Portishead Branch Line (MetroWest Phase 1)

9.28 ExA.FI.D4.V1 – Appendix 5 to Application for Non-Material Change to draft Development Consent Order

The Portishead Branch Line (MetroWest Phase 1) Order

District level Licencing – consequential amendments arising from removal of Works from Schedule of Authorised Works

Drawing
**ASHTON VALE ROAD
PEDESTRIAN RAMP DESIGN**

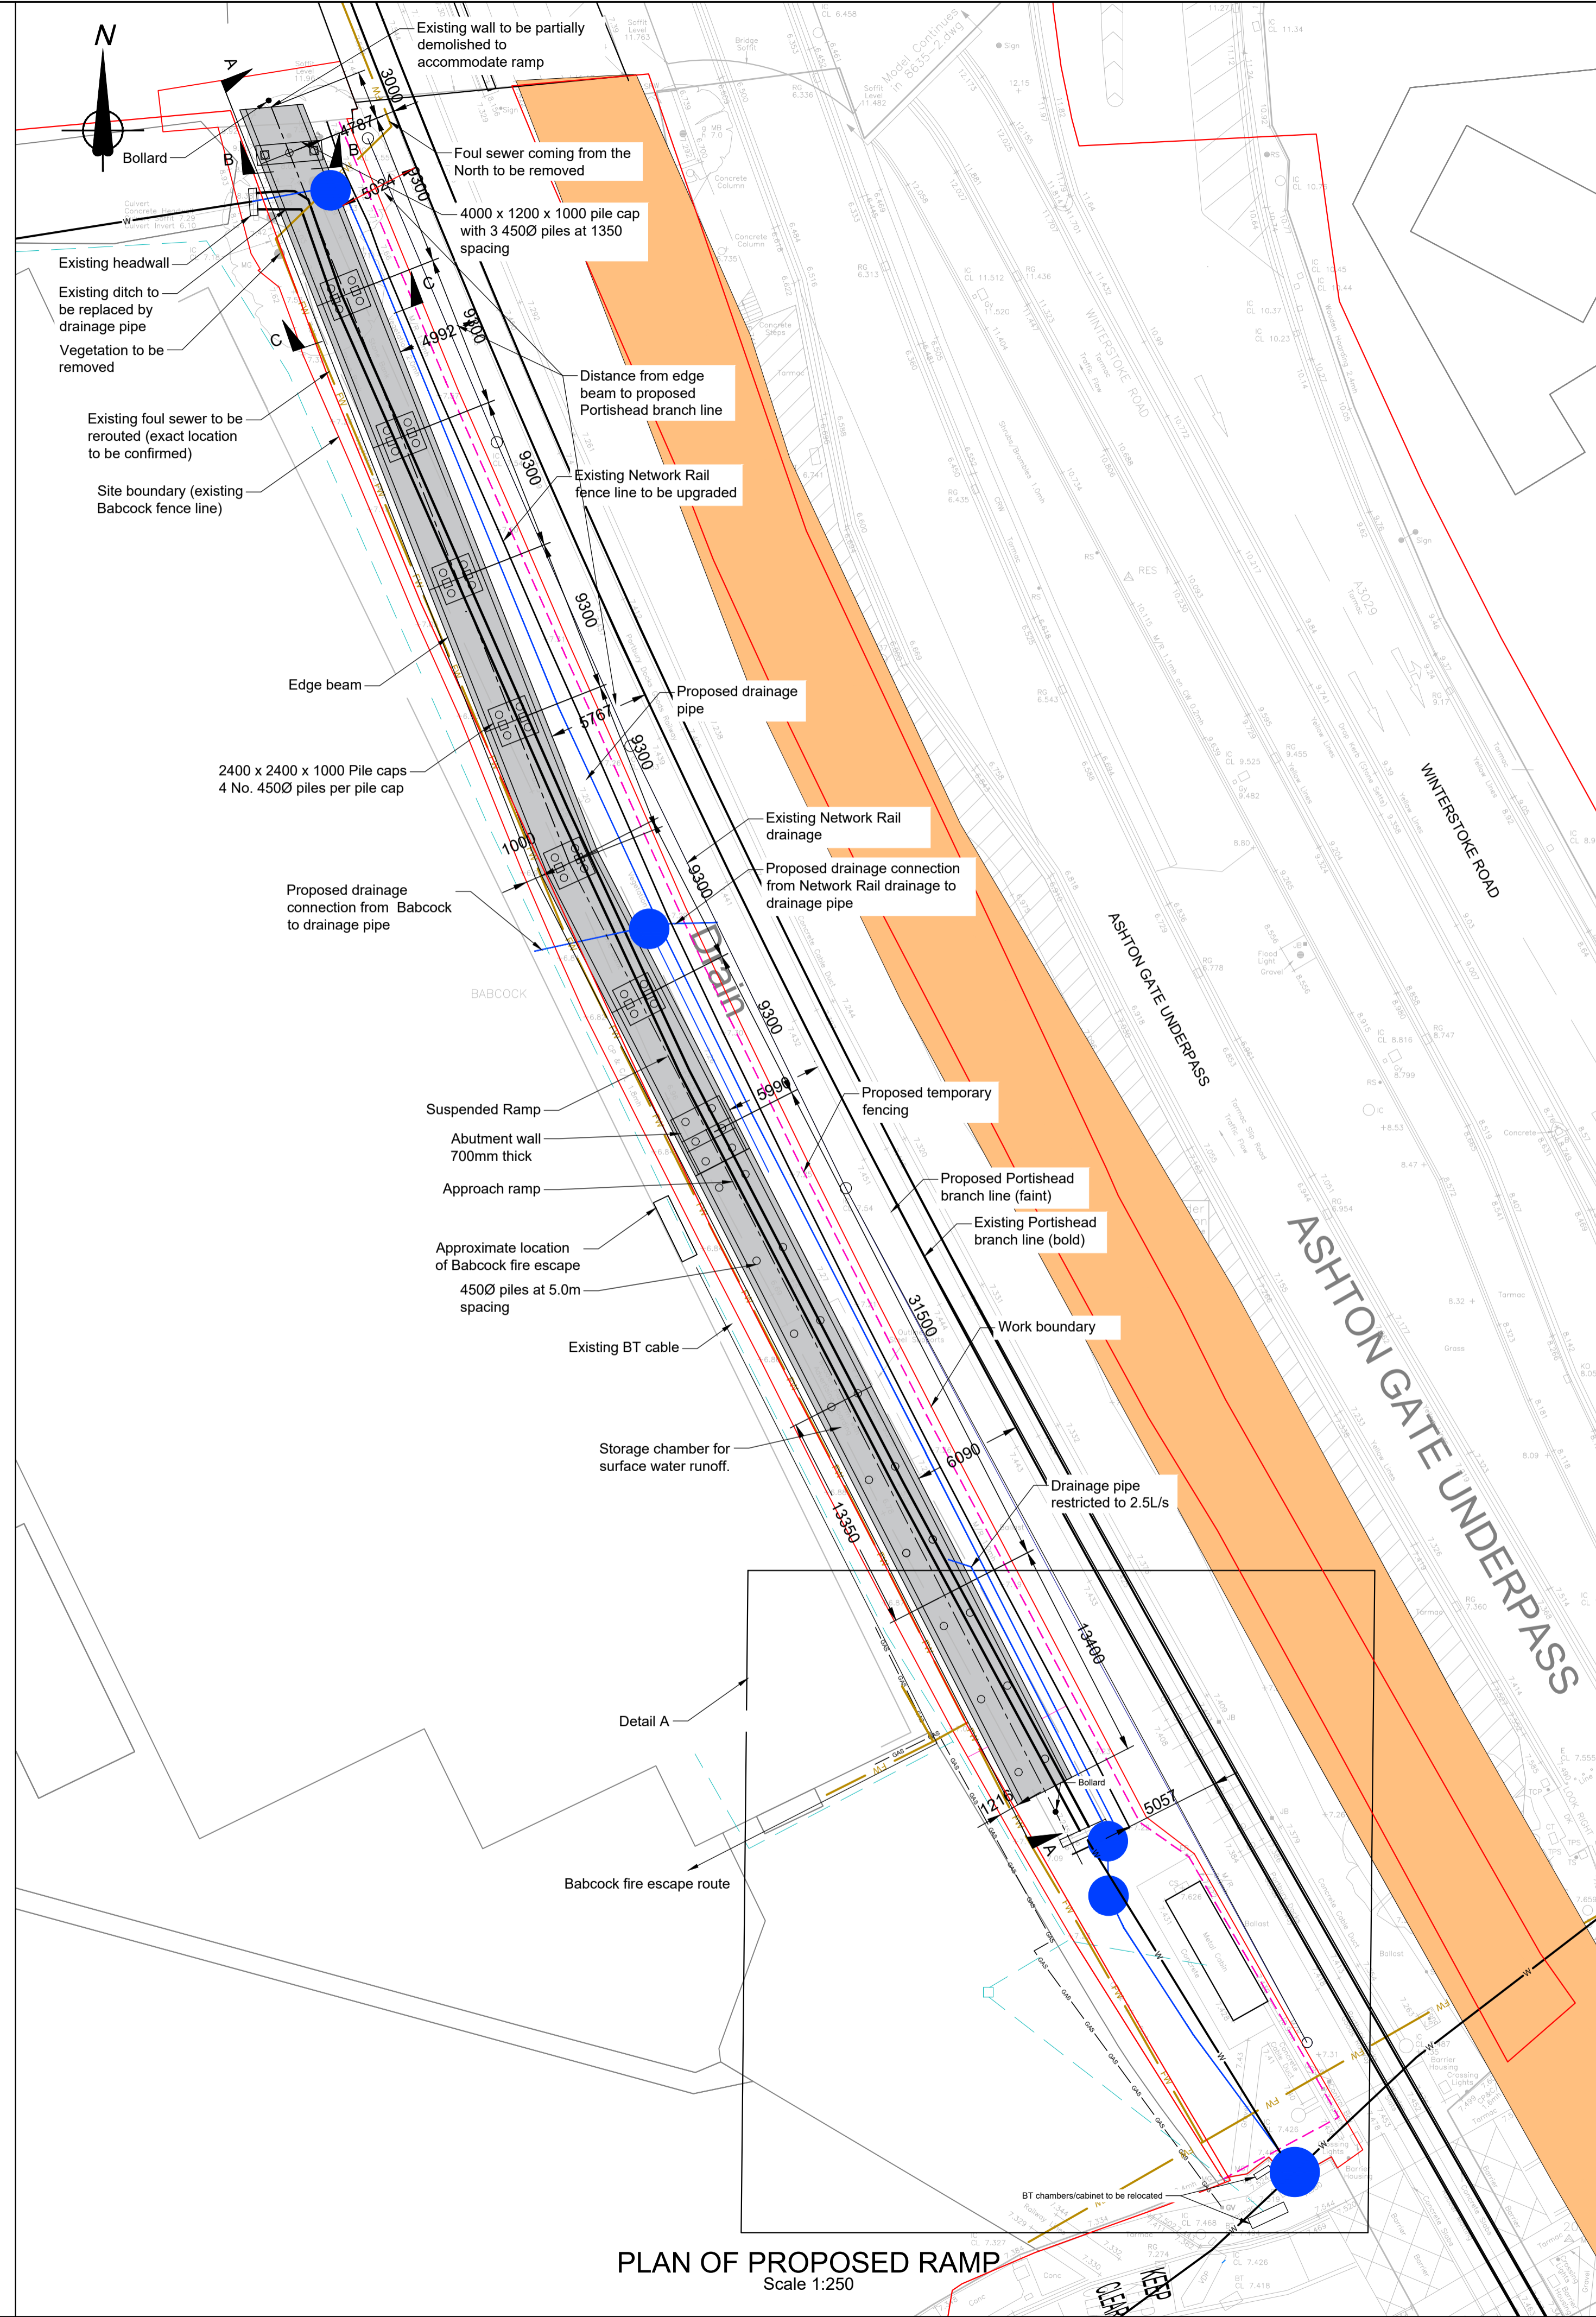
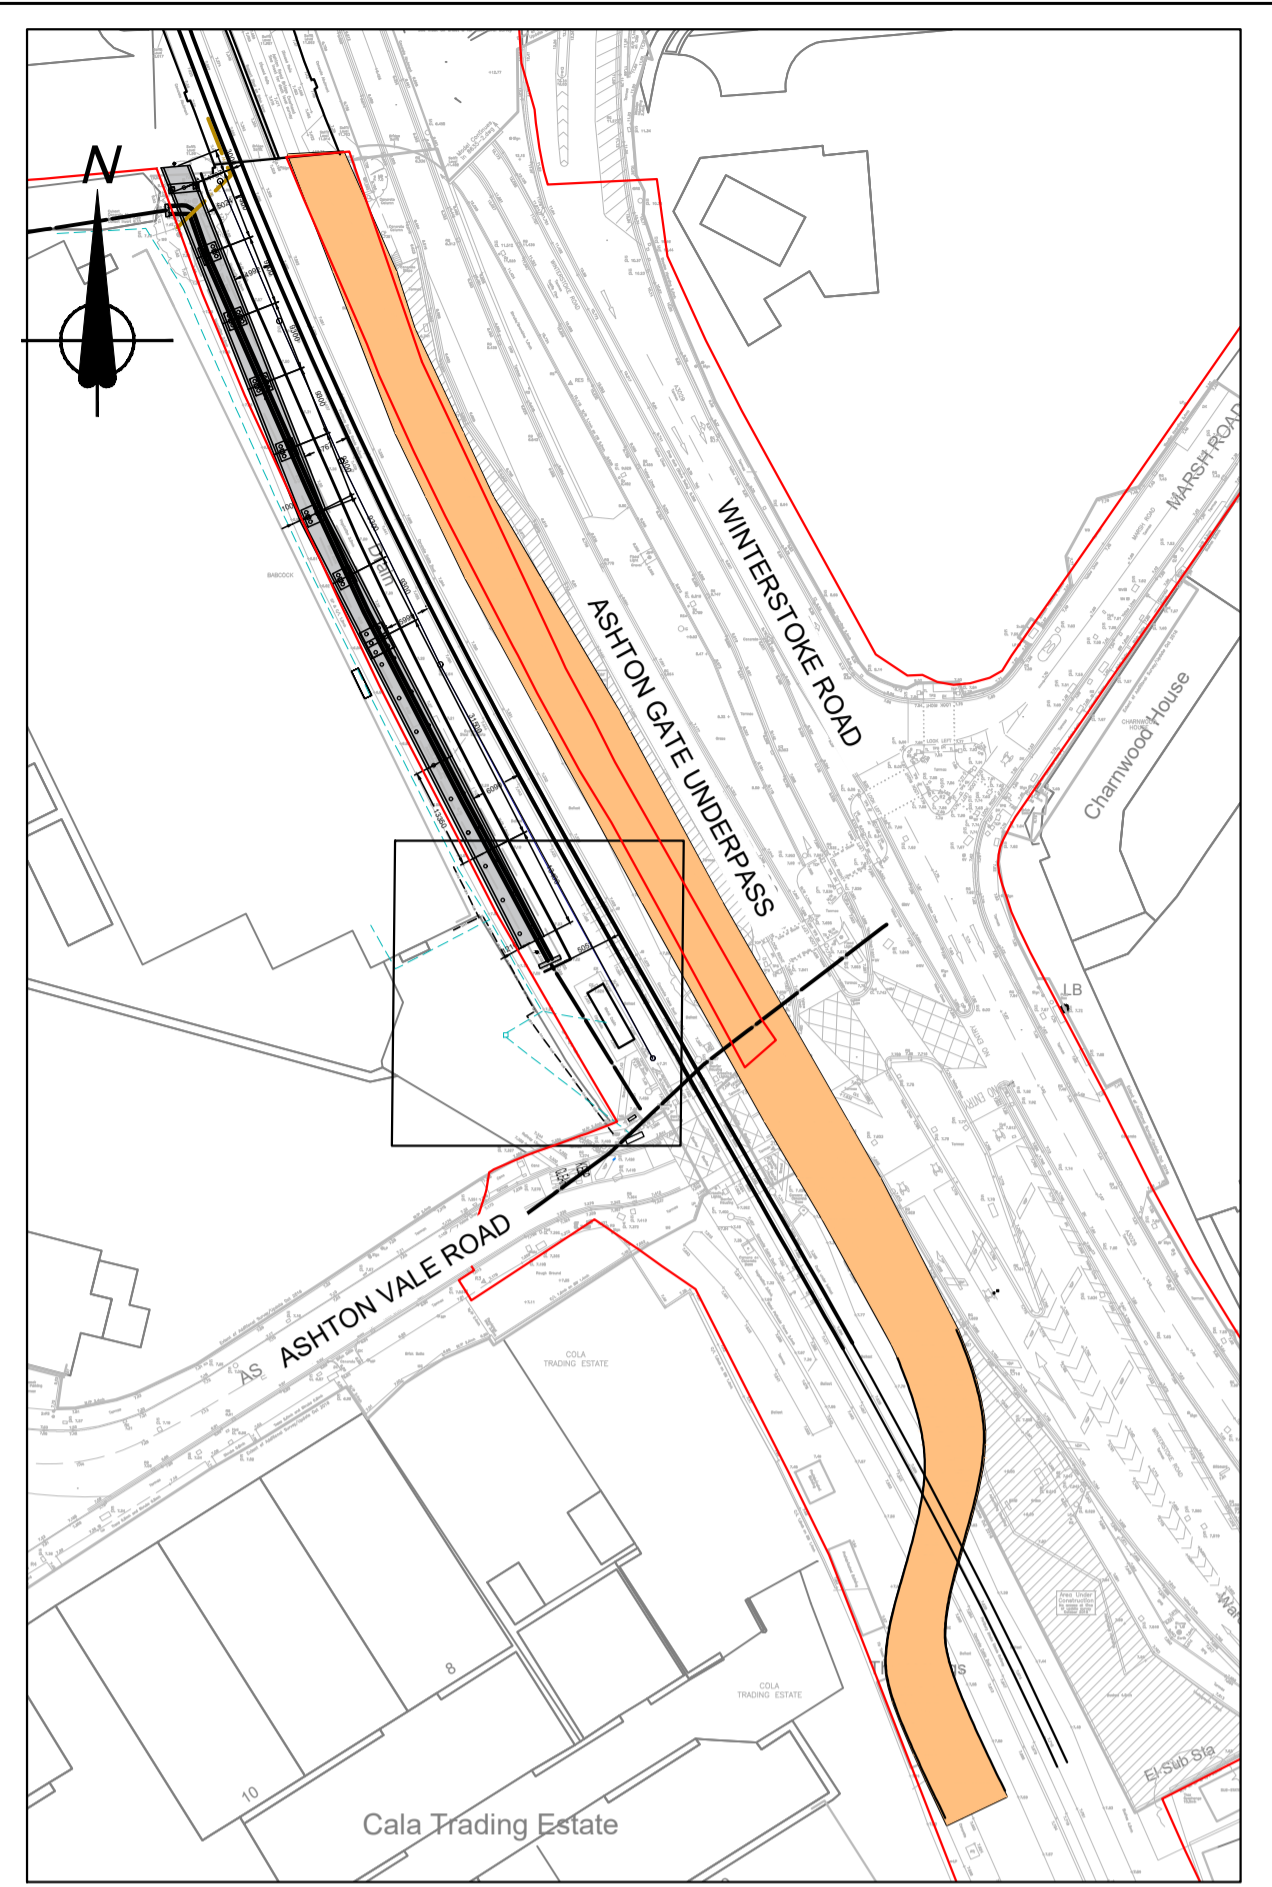
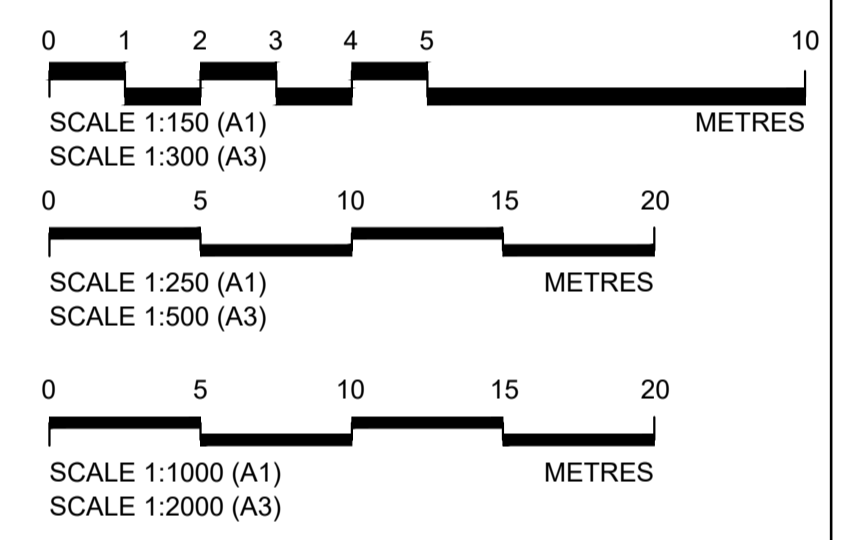
In addition it also includes the proposed amendments to the DCO Scheme to remove the pedestrian ramp (Work 27) providing a connection from Ashton Vale Road to Ashton Road.

- Land Plan sheets 15 and 16	Plots 15/125 and 16/05		None – Plots remain the same
Book of Reference	L		
-	Plot 15/125 and 16/05		None – Plots remain the same
Works Plans			
- Works Plan Sheets 15 and 16	References to Work No. 27		Work No. 27 will be removed
Environmental Statement			
- Chapter 4	Paragraphs 4.5.270- 274	To be delet	ted . Consequential changes to Chapters 1 and 3 and Non Technical Summary
- Chapter 11	Paragraph 11.6.90	To be remo	oved
- Chapter 16	Table 16.3, page 16.25	References	s to ramp to be removed
	Table 16.8, Page 16-55		s to ramp to be removed
	Para 16.10.9, page 16.75		s to ramp to be removed
	Table 16.15, page 16-79		s to ramp to be removed
	Table 10.15, page 10-79	Kelelelices	s to ramp to be removed

Work 27 removed
